16 June 2020

**6 HASSALL STREET, PARRAMATTA SSDA 9670 (COUNCIL REFERENCE NCA/3/2019)
ITEM B23 STORMWATER MANAGEMENT SYSTEM
SUMMARY FOR STORMWATER OPTION 2 – WESTWARD DIRECTION**

As requested, please find enclosed concise summary for the 6 Hassall Street alternative stormwater management route:

Drawing Number
CV-BB-06.05

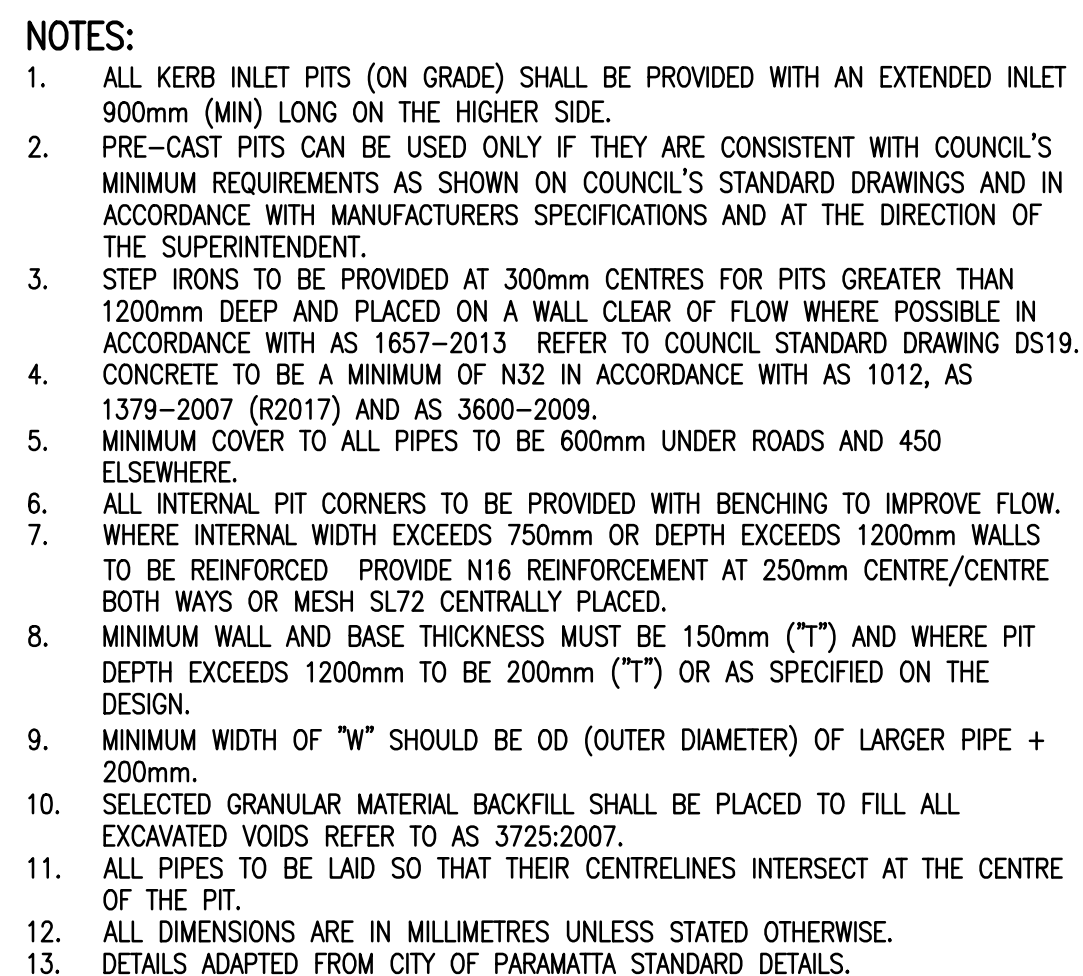
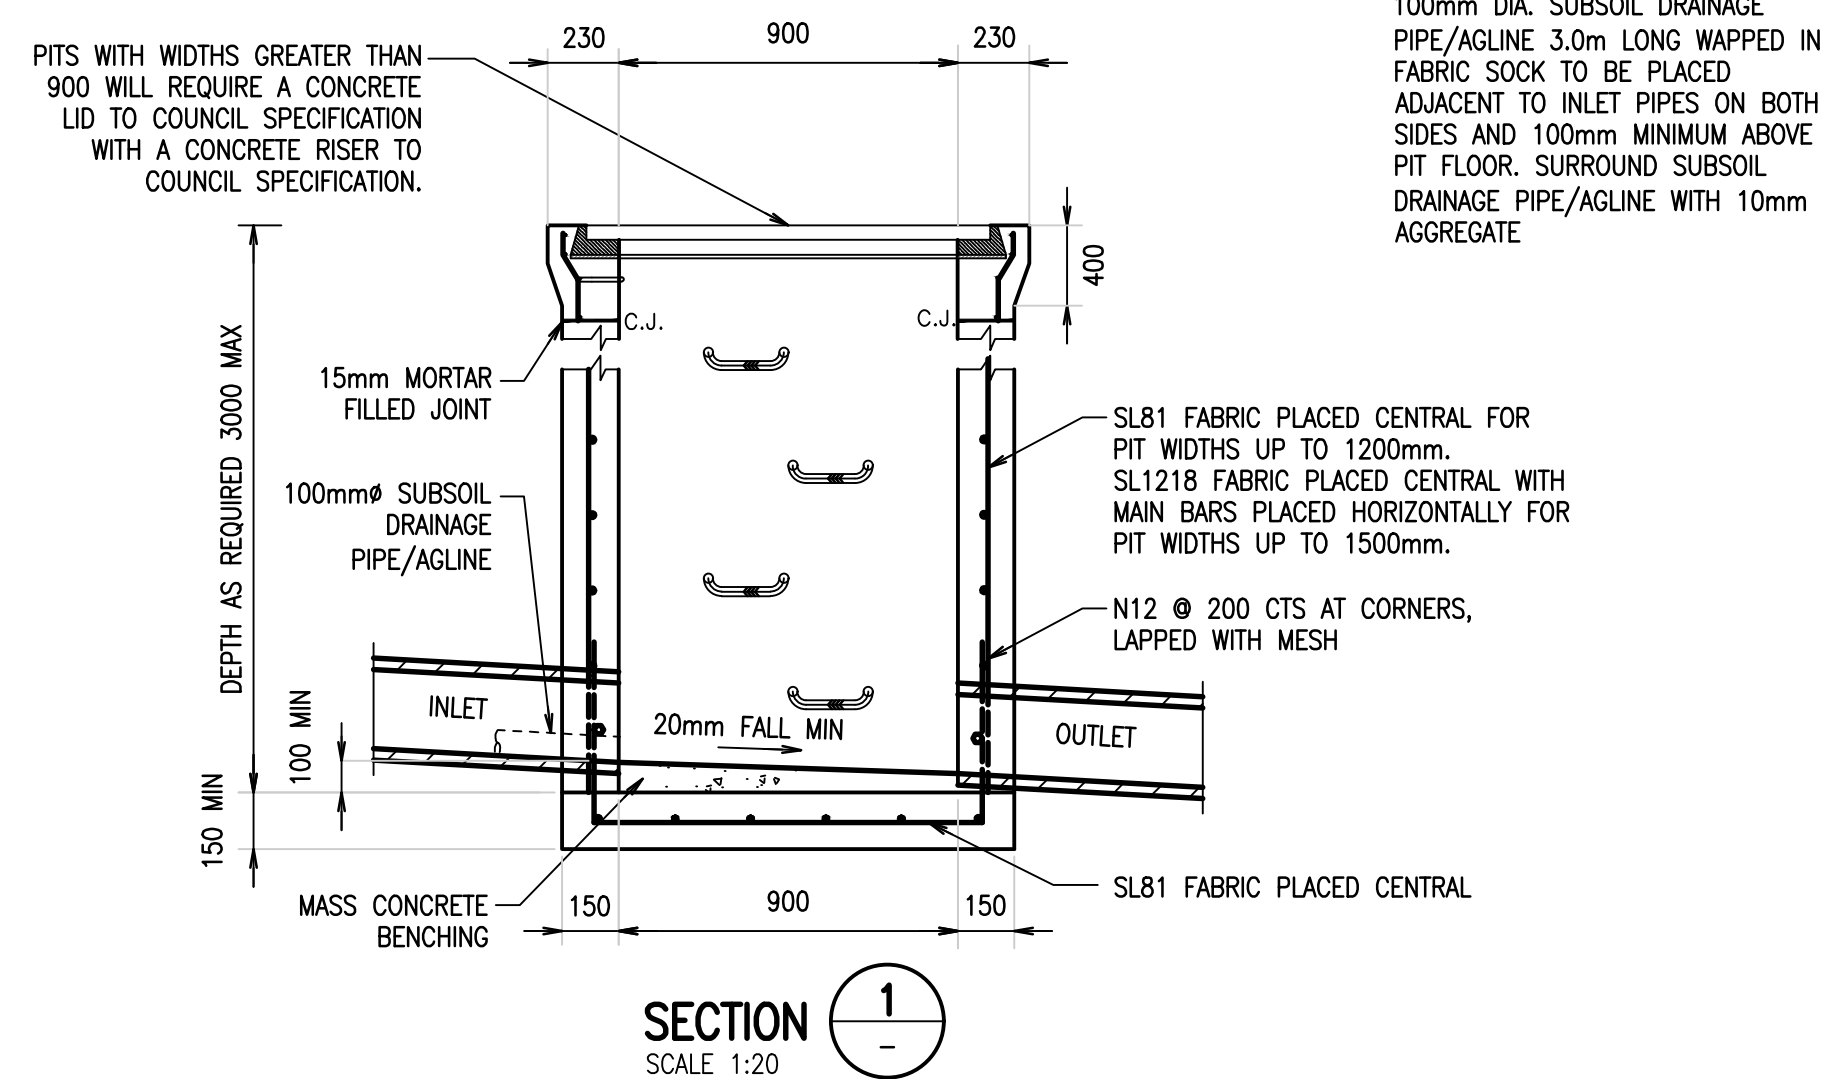
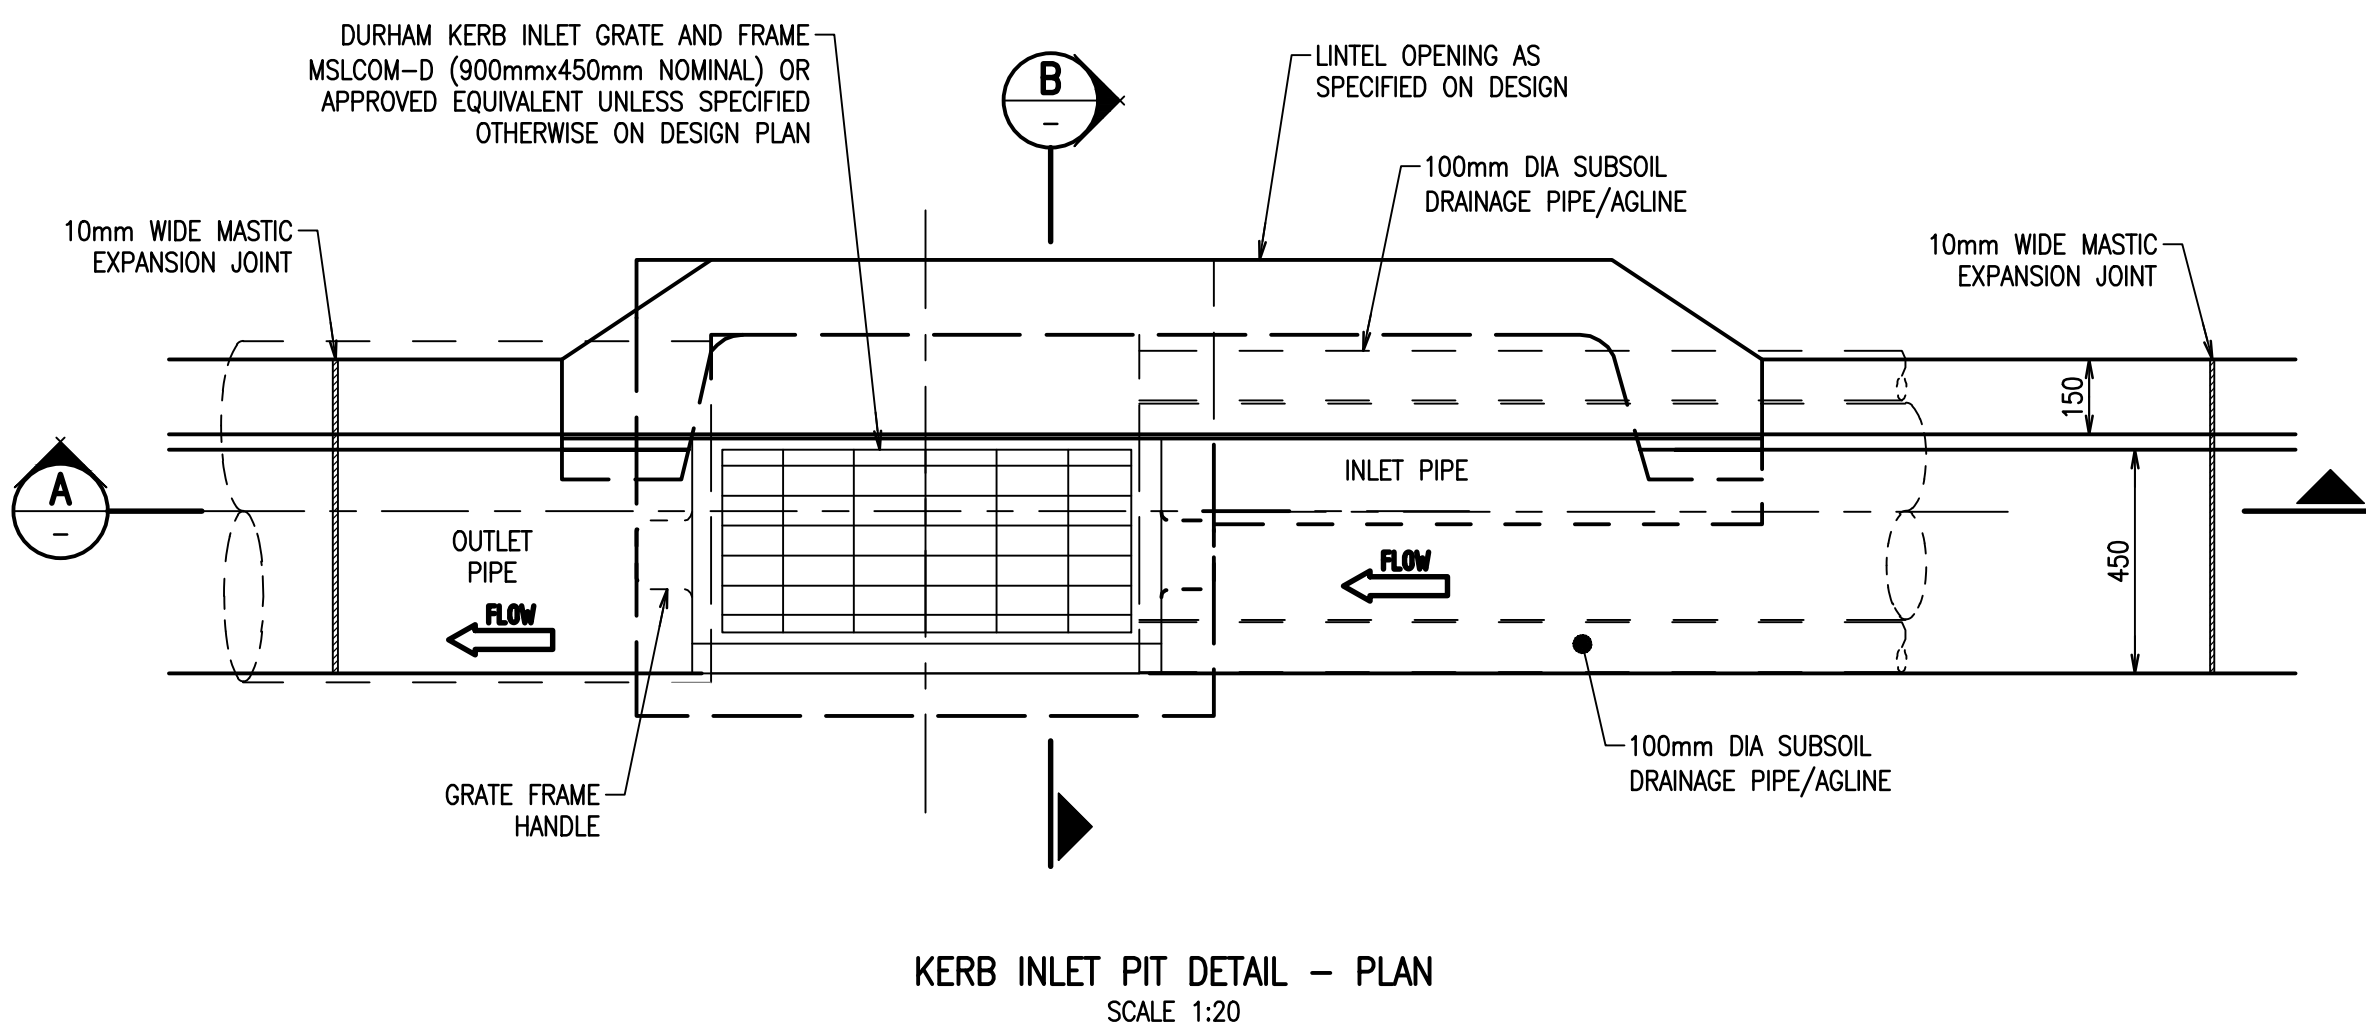
3. The project team has developed concept design for “option 2 – westward direction” and submitted to City of Parramatta Paul Clark on 15 June 2020 consisting of the following Robert Bird Group Civil concept drawings:

- i. CV-BB-06.05 [3] – STORMWATER MANAGEMENT PLAN
 - ii. CV-BB-06.10 [2] - STORMWATER DETAILS
 - iii. CV-BB-06.25 [2] - STORMWATER LONGITUDINAL SECTION (ALTERNATIVE CONNECTION POINT)

4. The Robert Bird Group concept drawings demonstrates the preference and viability for the “stormwater option 2” route and demonstrates developed concept design resolution for levels, hydraulic grade, services, hydraulic capacity, pits and road treatment.

5. These key issues associated with stormwater option 1 and benefits included in option 2 are summarized below:
 - i. Option 1 is identified to include substantial quantity of crossover points with existing underground services.

- ii. The Option 1 proposed stormwater pipe is relatively shallow and is a high risk for clashes with several existing services which cross its path. Options to lower the pipe are limited by the existing pipe level at the connection point.

- iii. The Option 2 connection to the west crosses less services and has greater flexibility with pipe depth due to the availability of a deeper connecting point.

- iv. Disruption to services for Option 1 is likely, in the event that clashes cannot be designed out, it is a requirement that service relocations will result in disruption to services to other properties in the general vicinity during cut over.
 - v. Disruption to traffic flow associated with Option 1 is greater due to the increased length of trenching and potential services relocations. Option 2 being shorter requiring shorter construction period compared to Option 1, which will result in a significantly extended construction period.
6. The eastern connection (option 1) will necessitate additional disruption to traffic along Hassall Street and Charles Street intersection where traffic density has significantly increased due to Harris and Macquarie Streets associated works.
